RE: Re - 2025/92161 - Whitehall Road West

The thing I am unclear about from your comments is whether they apply only to C26, or to C28 as well. Under the heading, "Condition 28", is a blank space.

Drawing No: 23/341/EXT/002
 Job No: 23-341
 Revision: 09.06.25

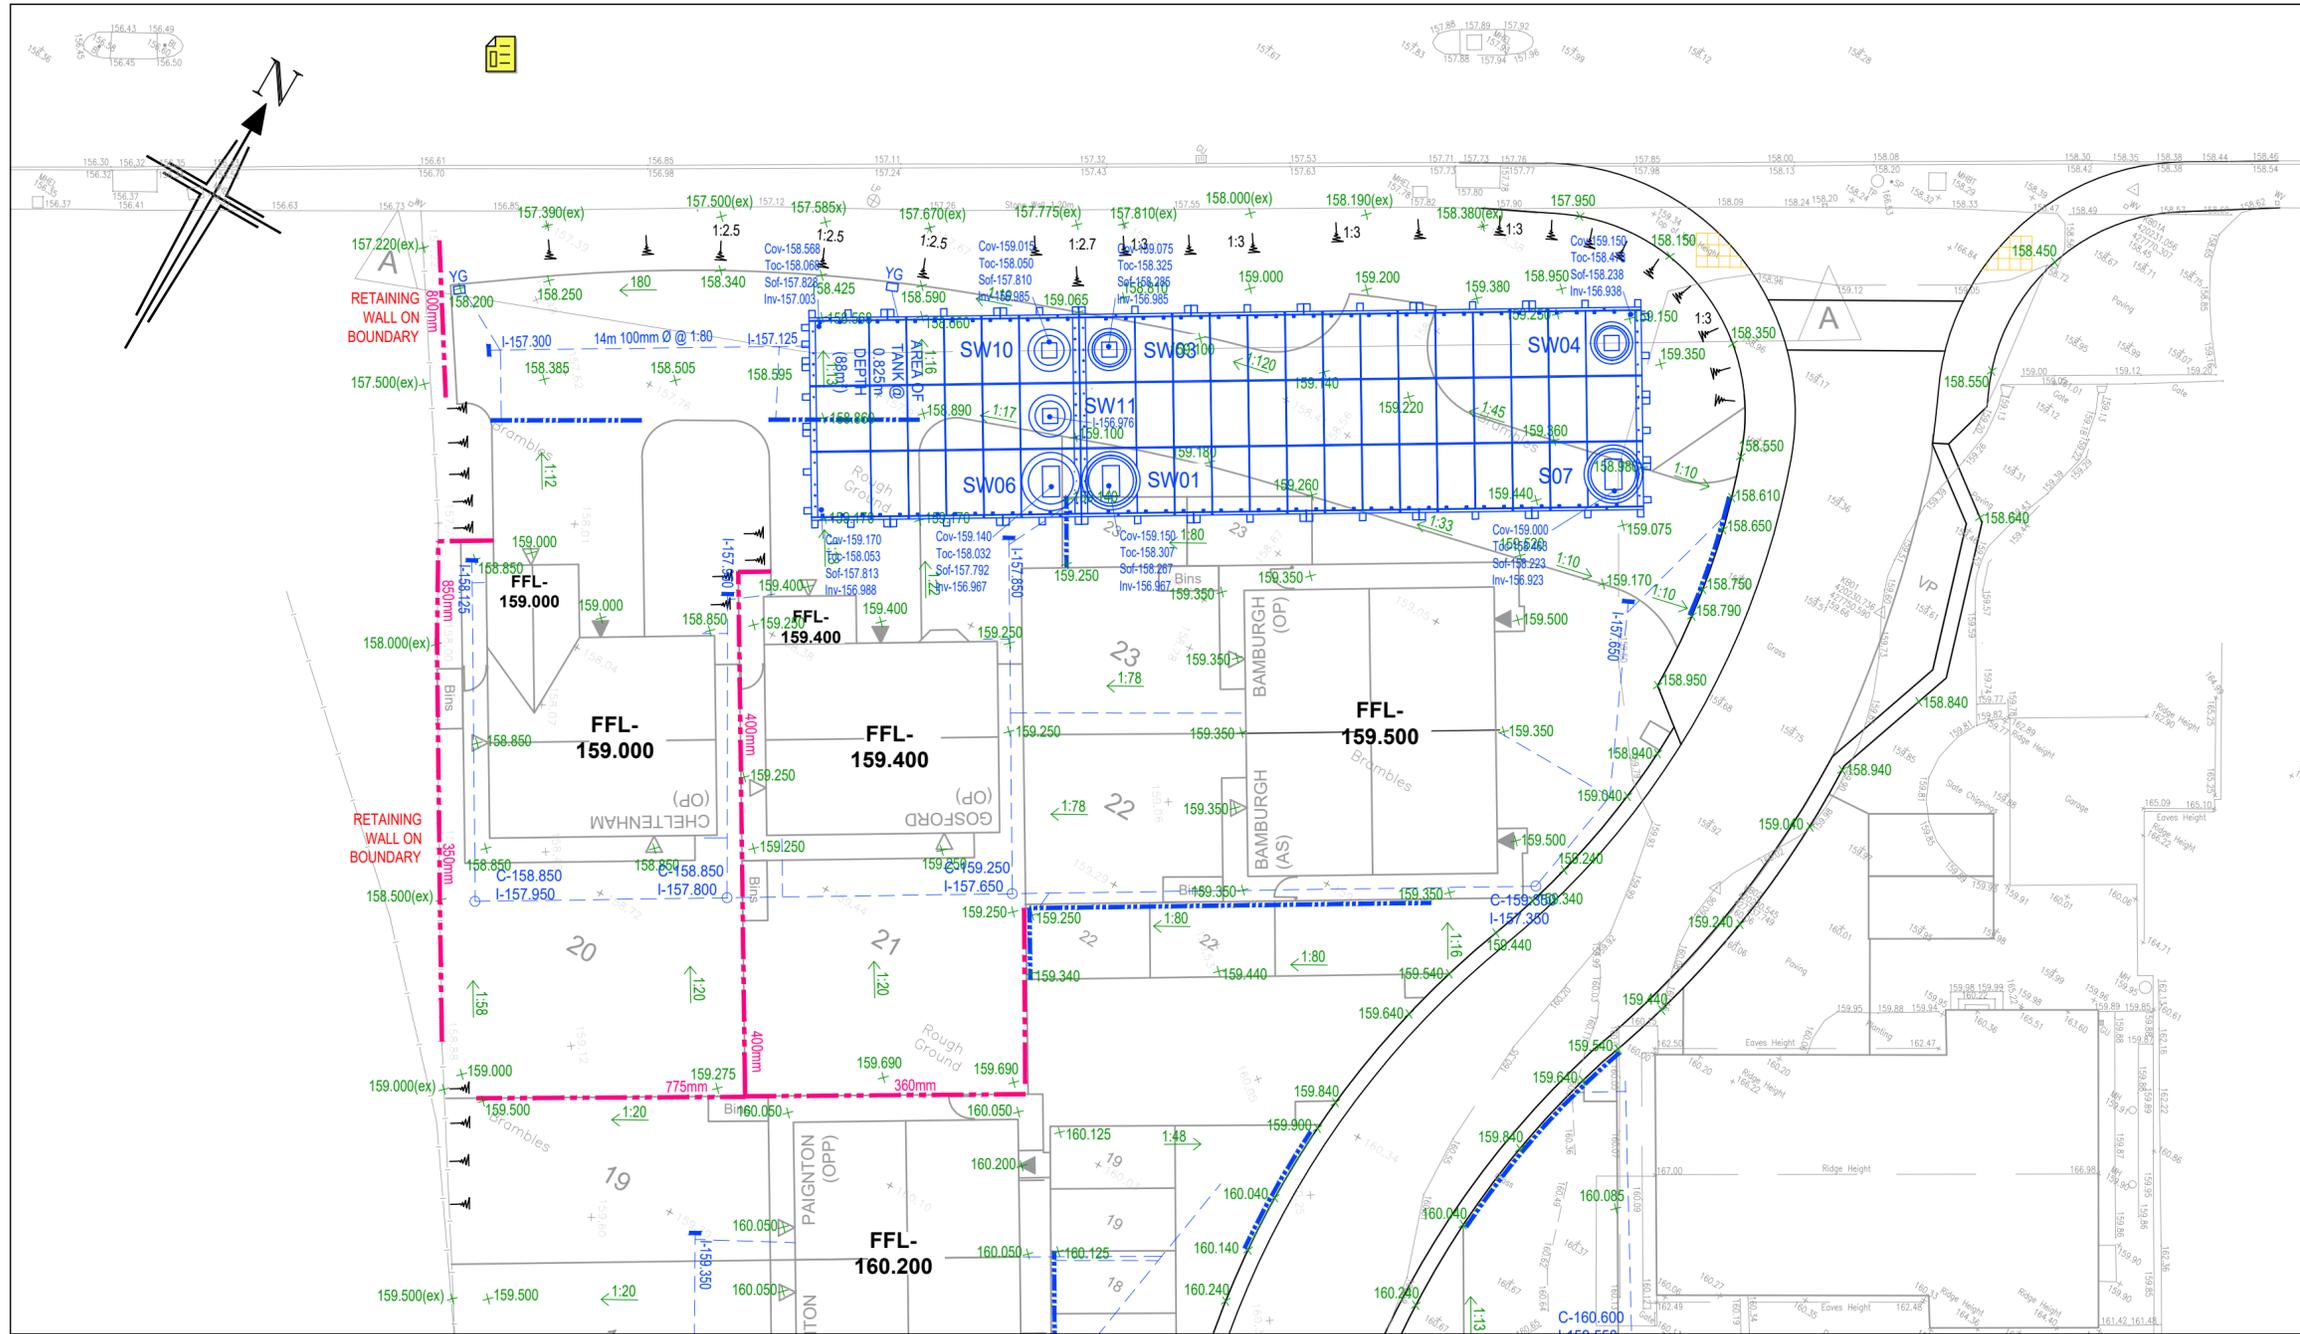
How are you going to desilt the tank, what with. How does the vehicle required get access to the tank.

Flow controls will need to be checked. If they are to be removed, the neoprene seal will have to be replaced.
